Date: 5th May 2021

Our Ref: A/55/21/DOC

Town & Country Planning Act 1990 (as amended)
Town and Country Planning (Development Management Procedure) (England) Order 2015
Approval of details reserved under condition imposed under A/219/17/PL relating to Conditions 3 -
contamination 11- Surface Drainage Water 13- SUDS Management 17 -Hedgerows 18 - Badgers
Land South Of Mayflower Way Angmering BN16 4AY

PROJECT TITLE: MayflowerWay Angmering	
PROJECT NUMBER: DD486	PLOT DATE: 03.02.21
DRAWING SCALE: 1:200	APPROVED BY: PD
PAPER SIZE: A1	DRAWN BY: JT
DRAWING TITLE: Existing Hedge Retention and Enhancement Plan - Condition 17

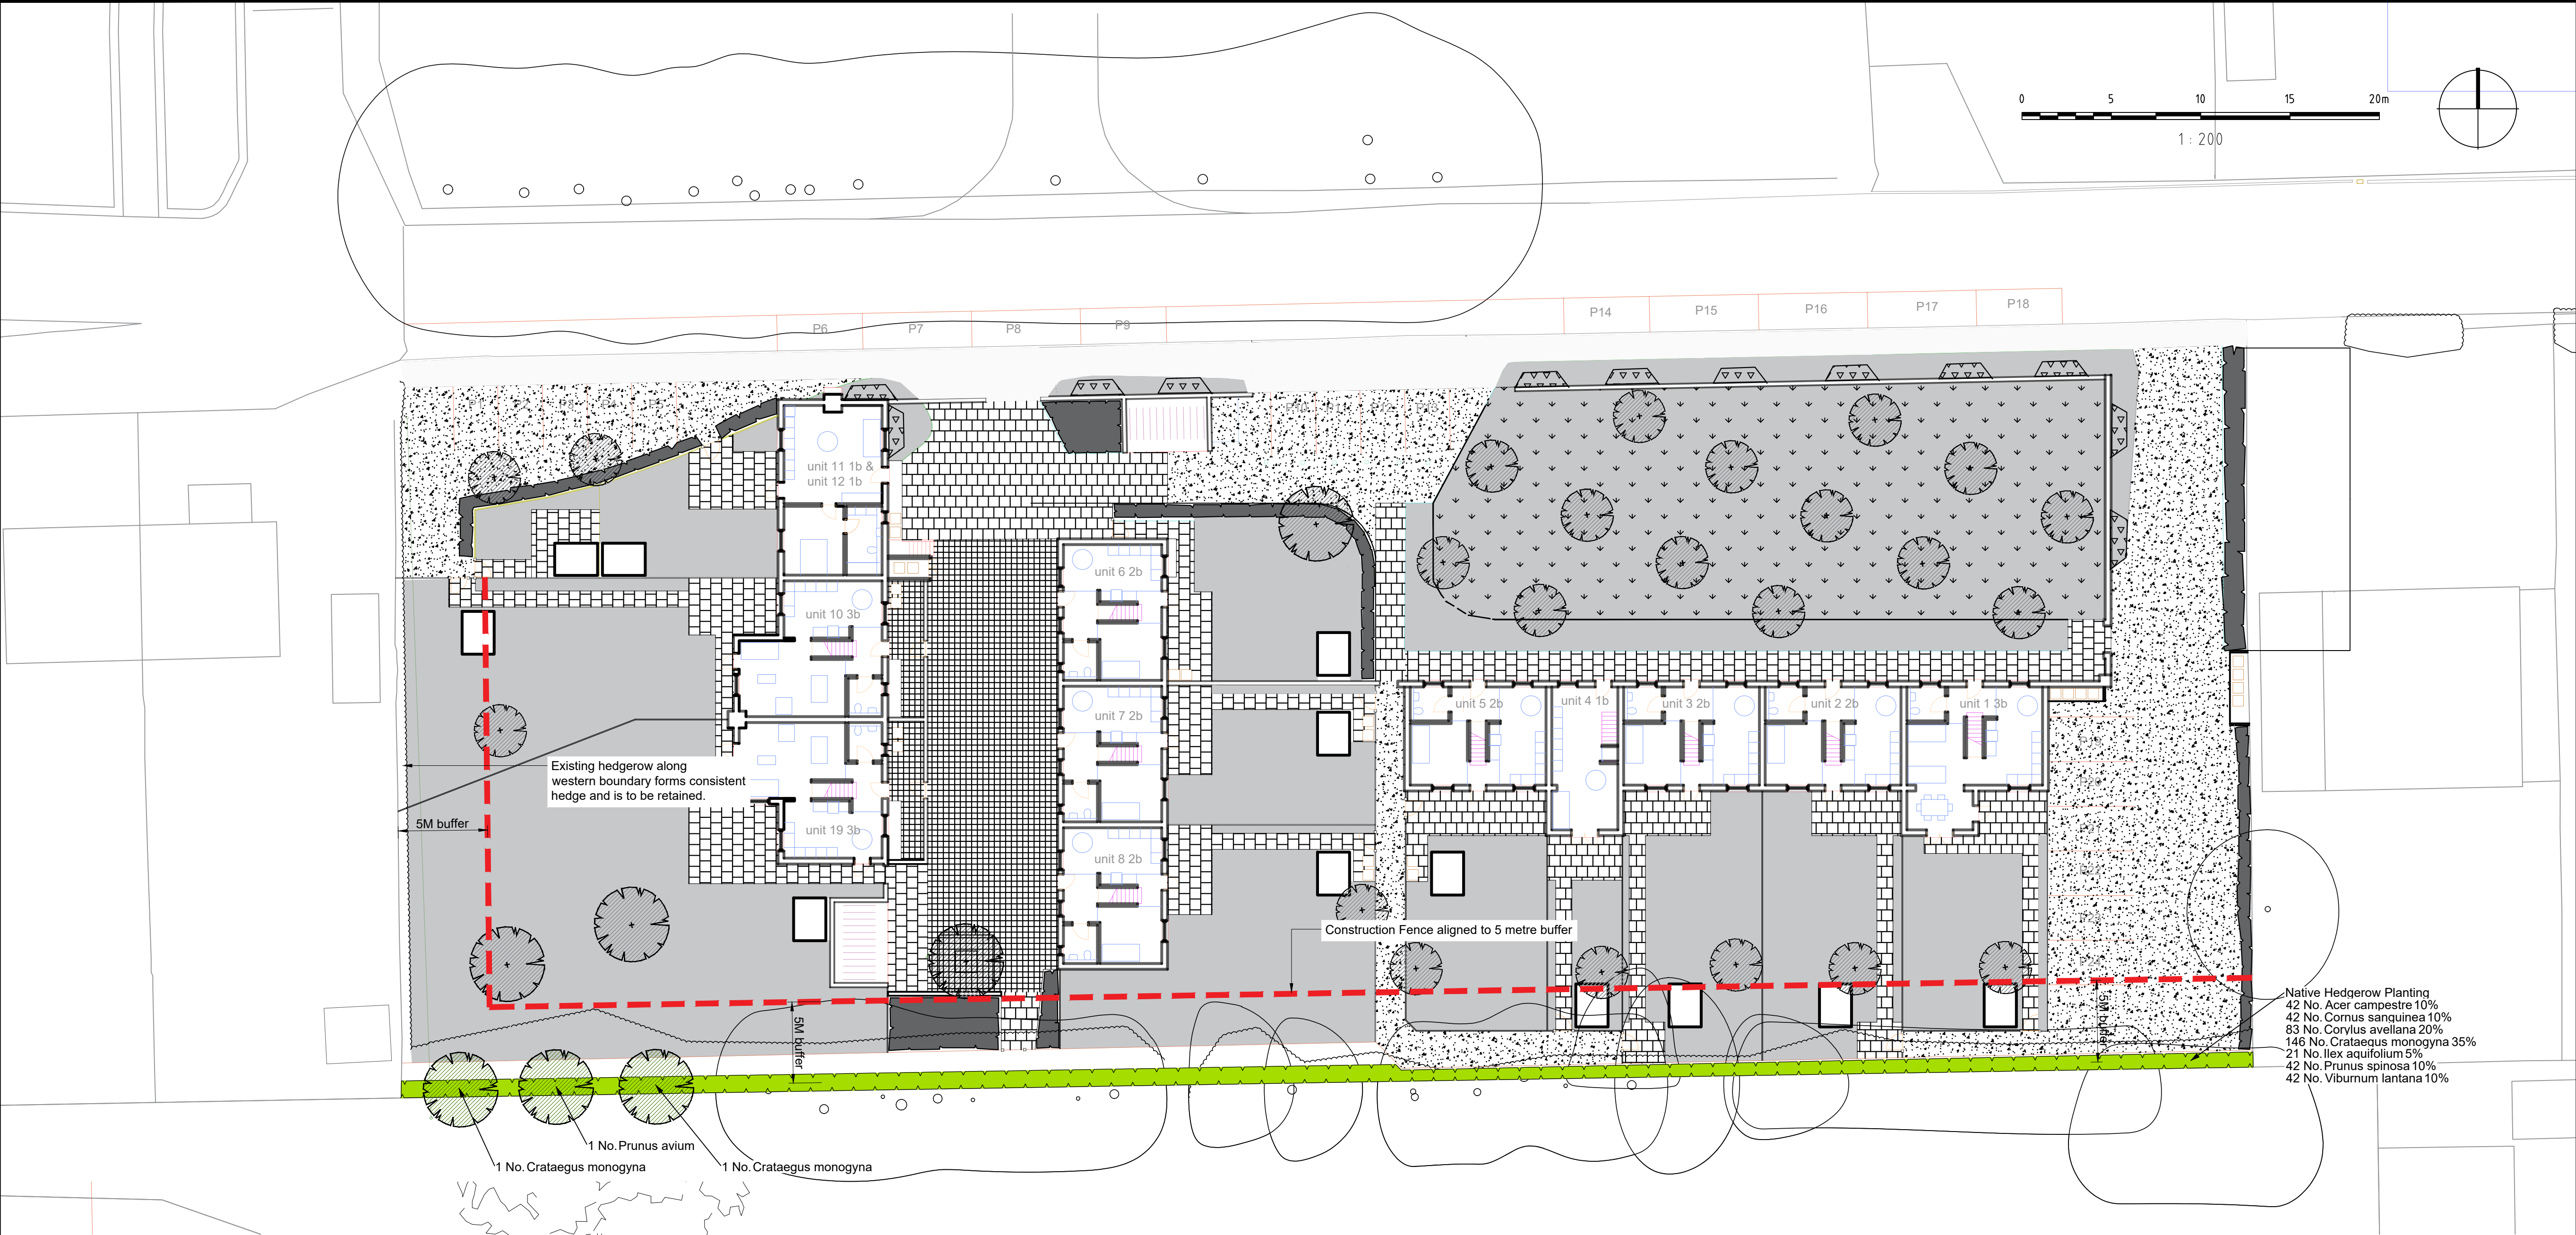
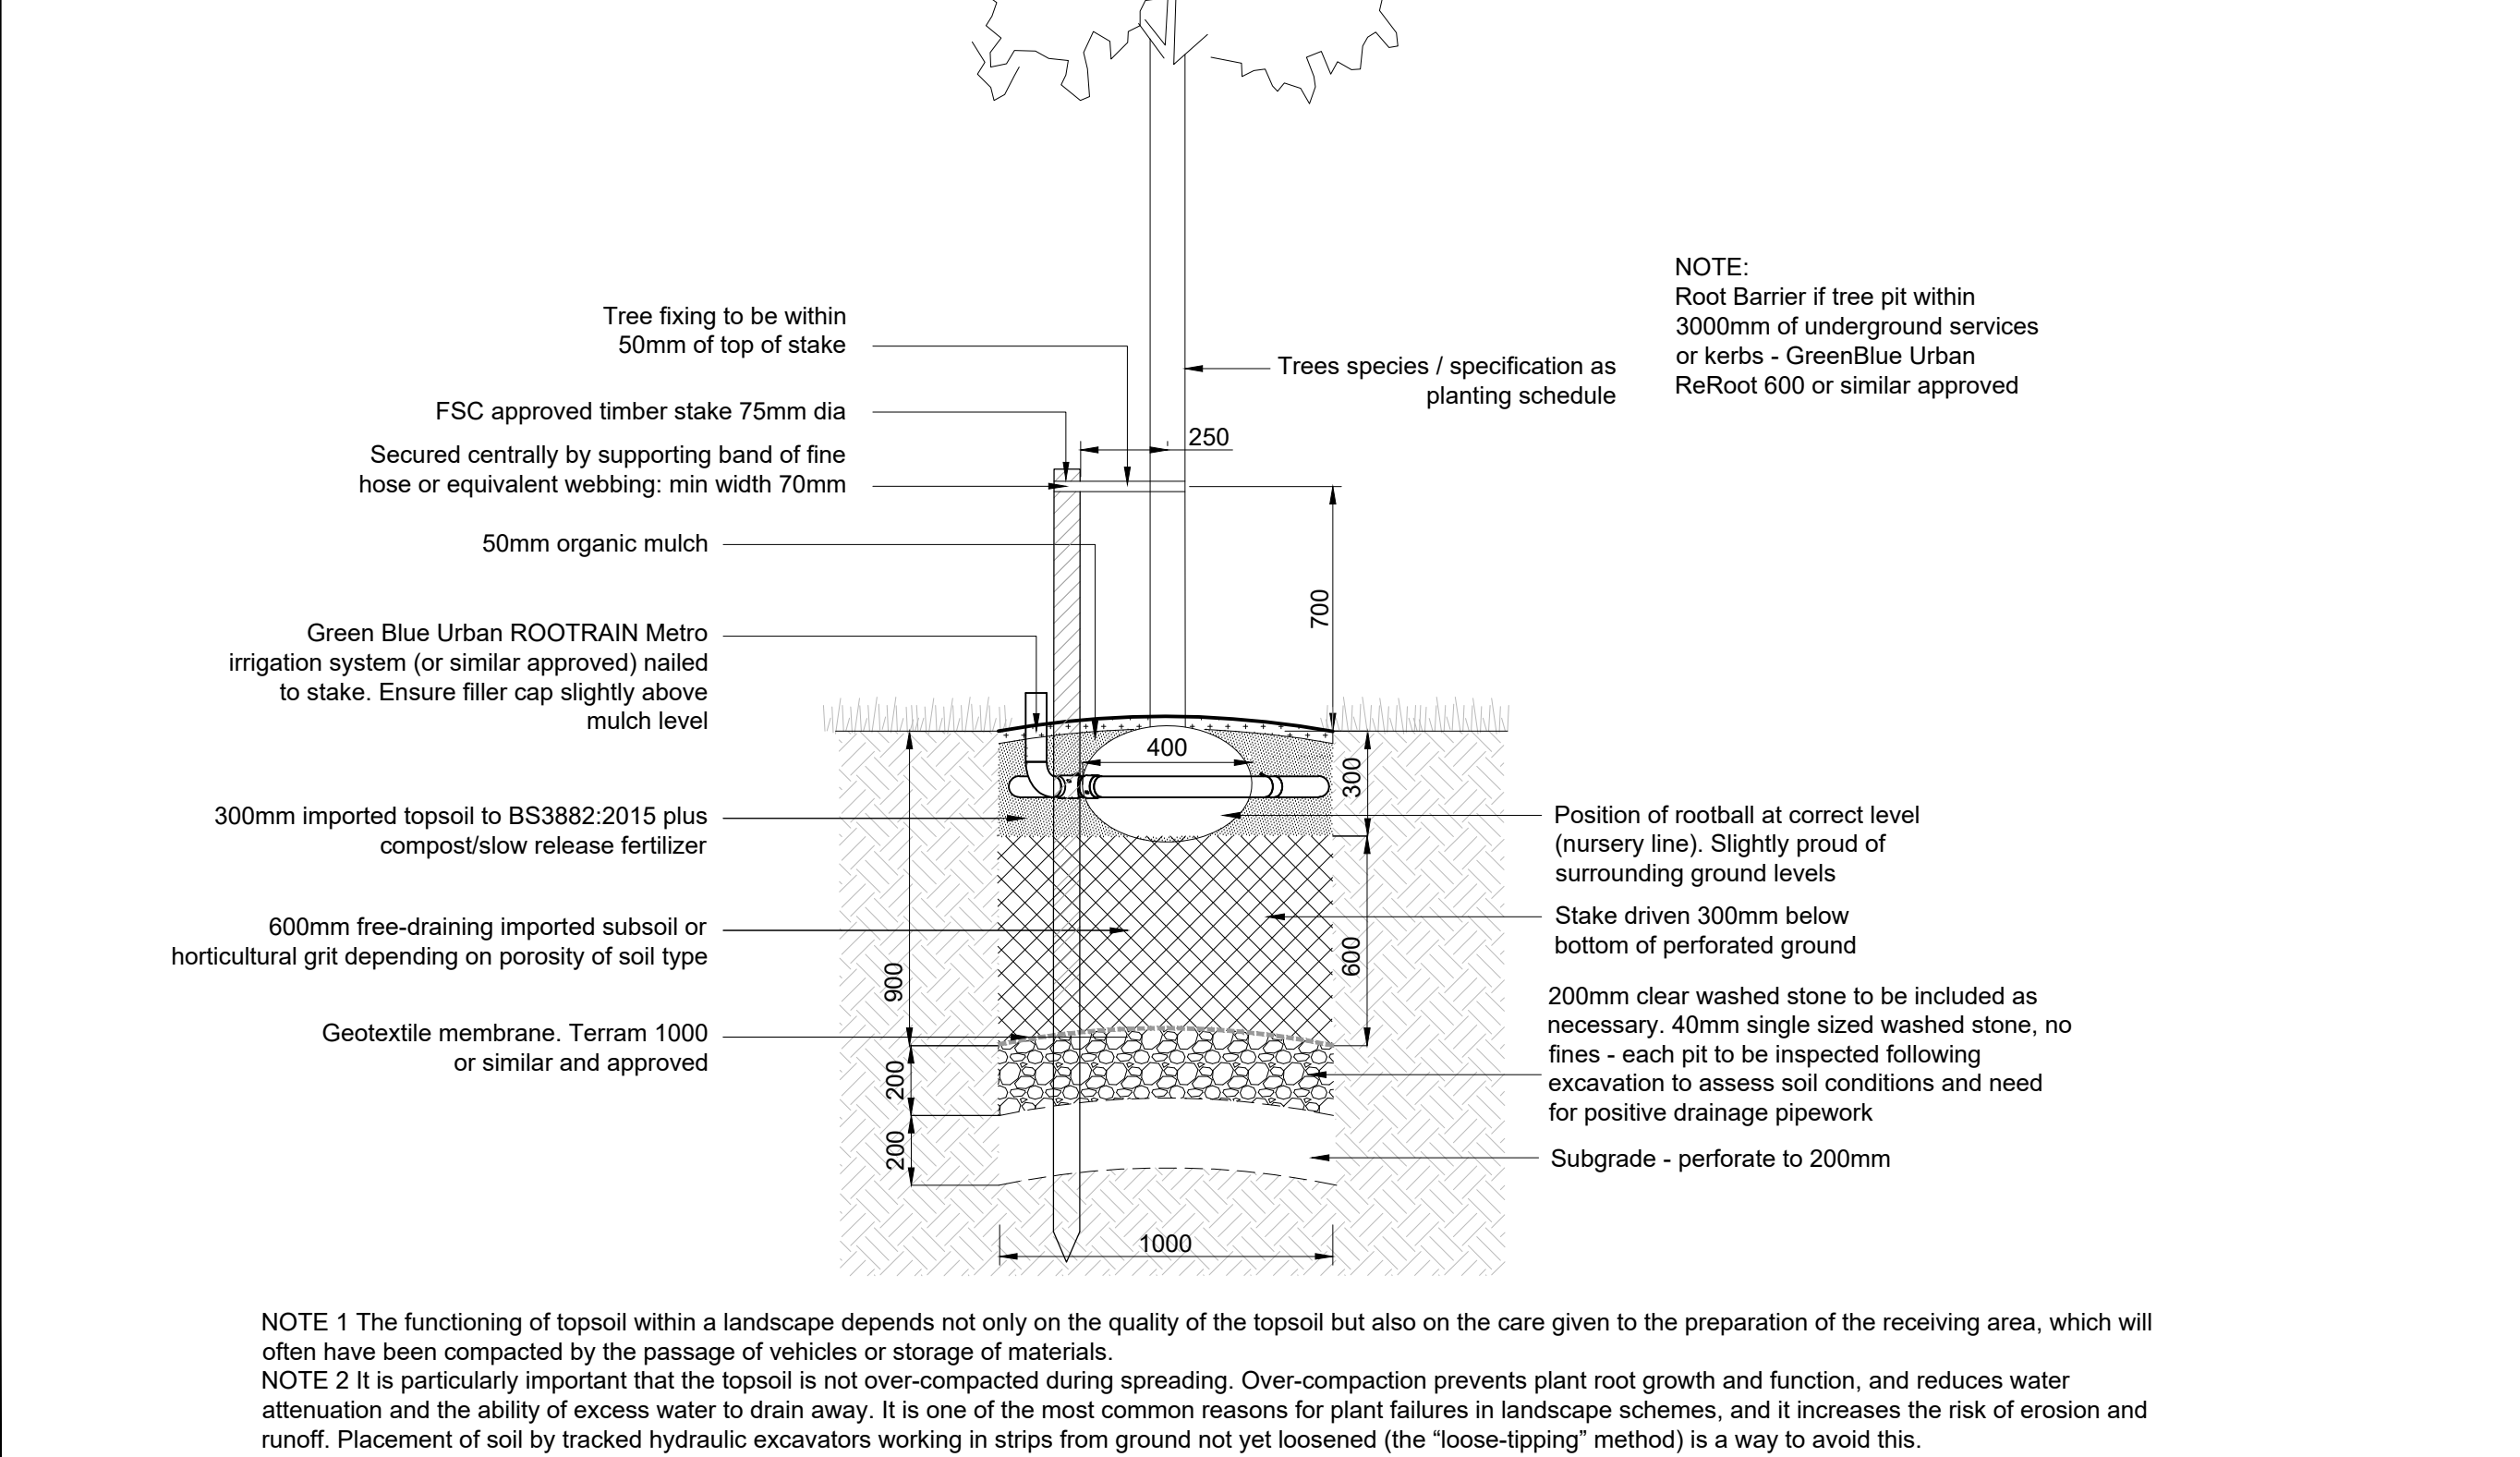
This condition is discharged in so far as submission of details relates and refers to drawing Existing Hedge Retention and Enhancement Plan drawing DD486L01 rev A which details and shows the new planting proposals. The detail has provided a good representation of existing features, retention details of existing vegetation and indicated improved habitat formation.

The information provided will provide a scheme suitable and fitting for location, with detail of quantities, species, and planting densities at time of planting.
